JENISHAY FARMS Civil Construction Plans

Including Grading and Erosion Control

El Paso County, Colorado

Prepared By:
Lodestar Engineering, LLC
P.O. Box 88461
Colorado Springs, CO 80908
October 2019

RURAL LOCAL – PAVED  
TYPICAL SECTION  
SCALE N.T.S.

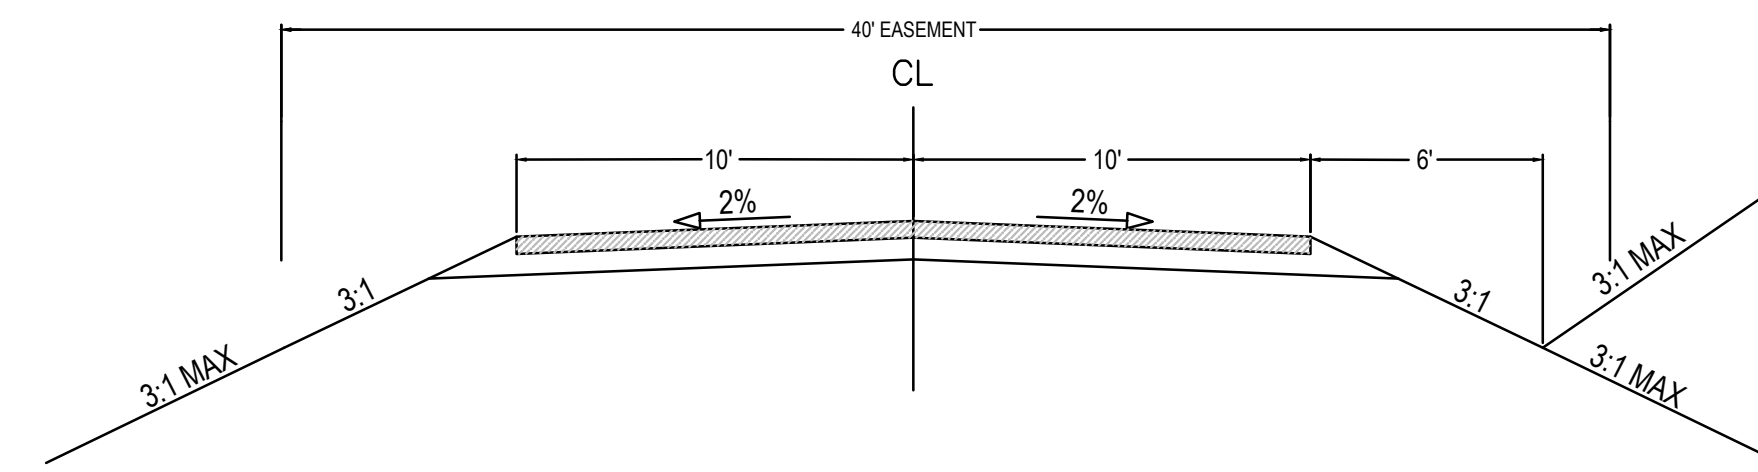
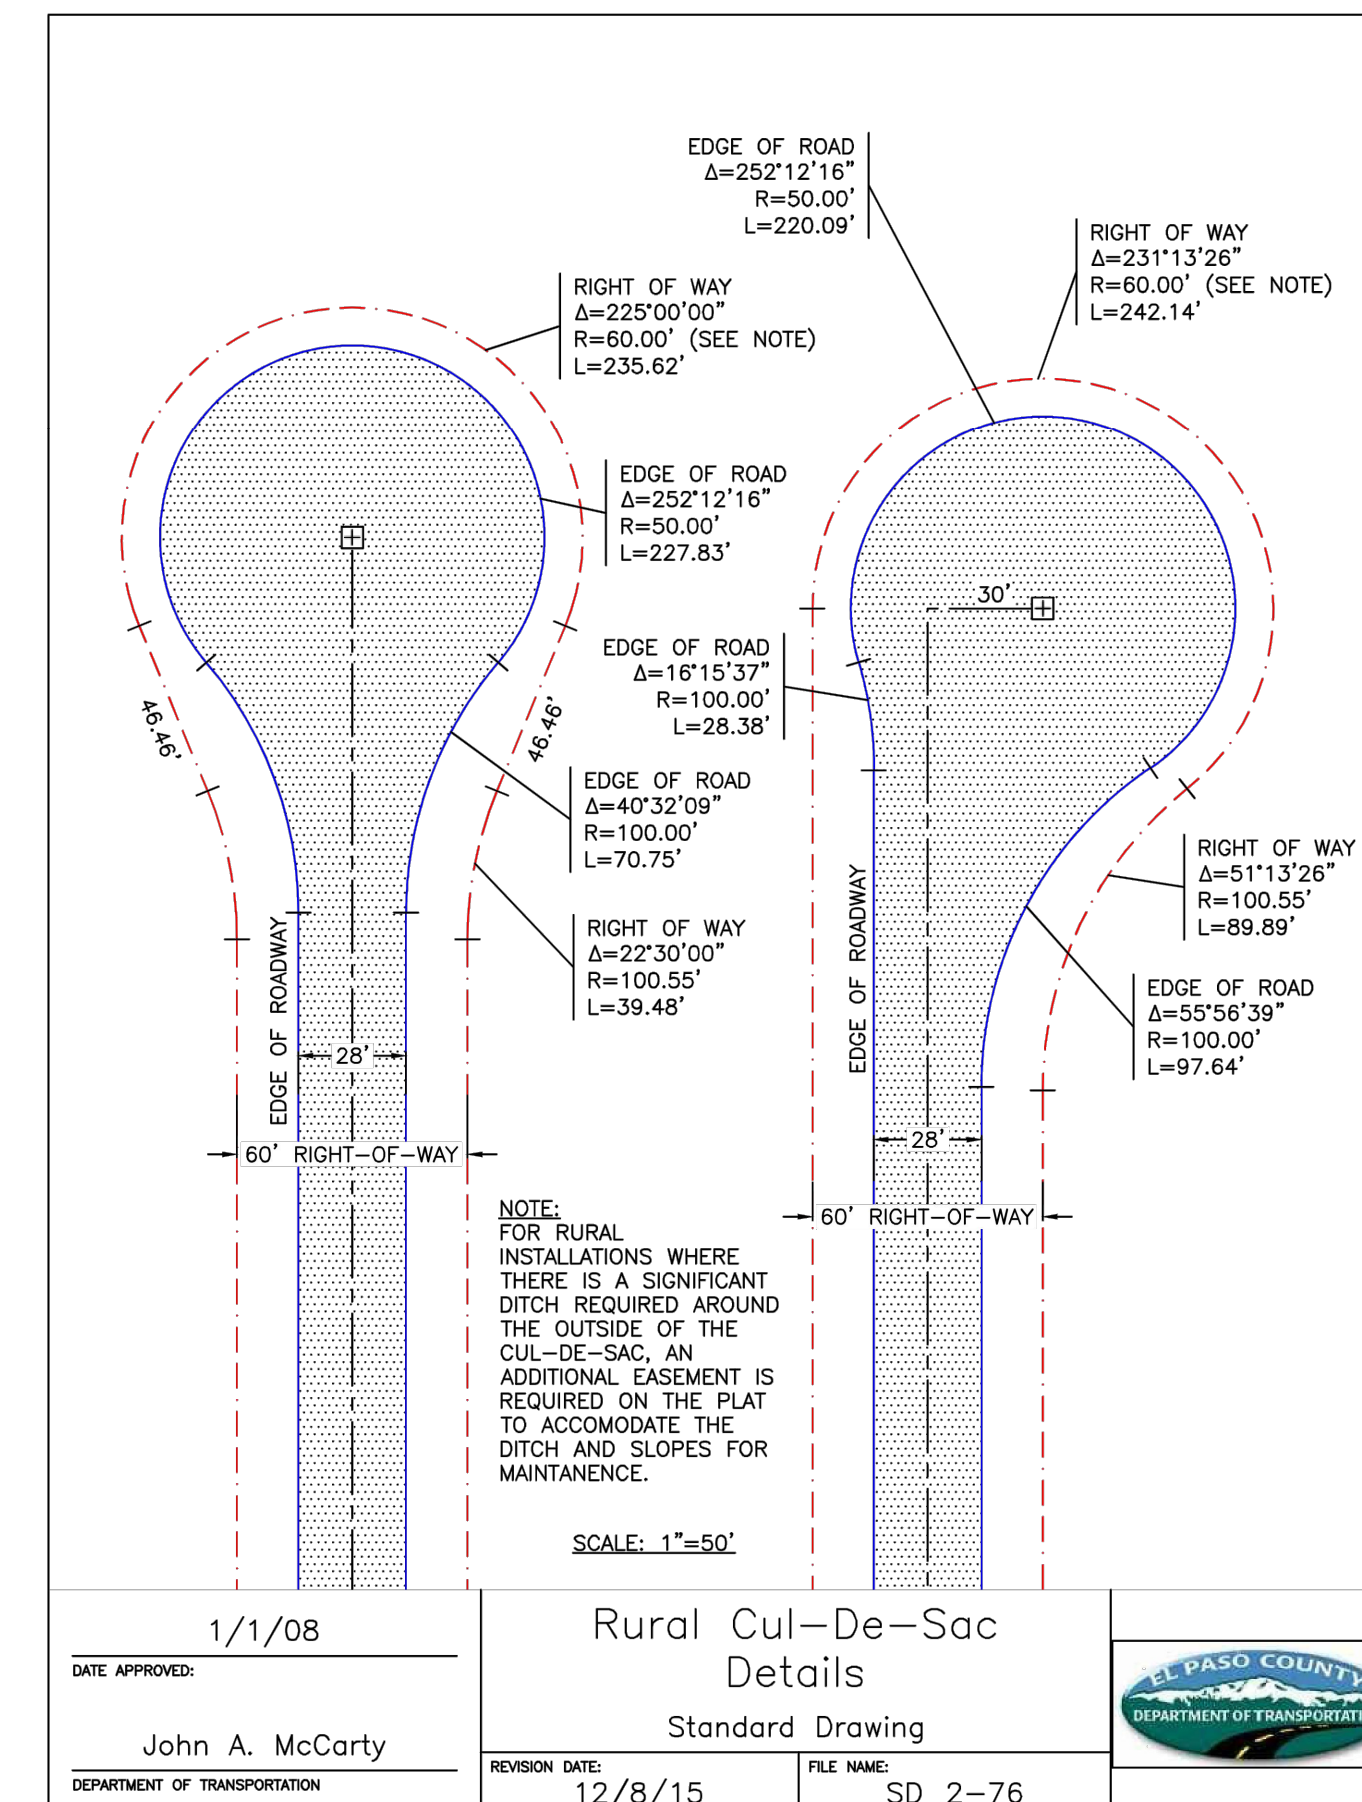
Revise grading to show subgrade or update the typical cross section to identify that this predevelopment grading and erosion control is to subgrade. See example below.

Provide a typical cross section for the private O&M road.
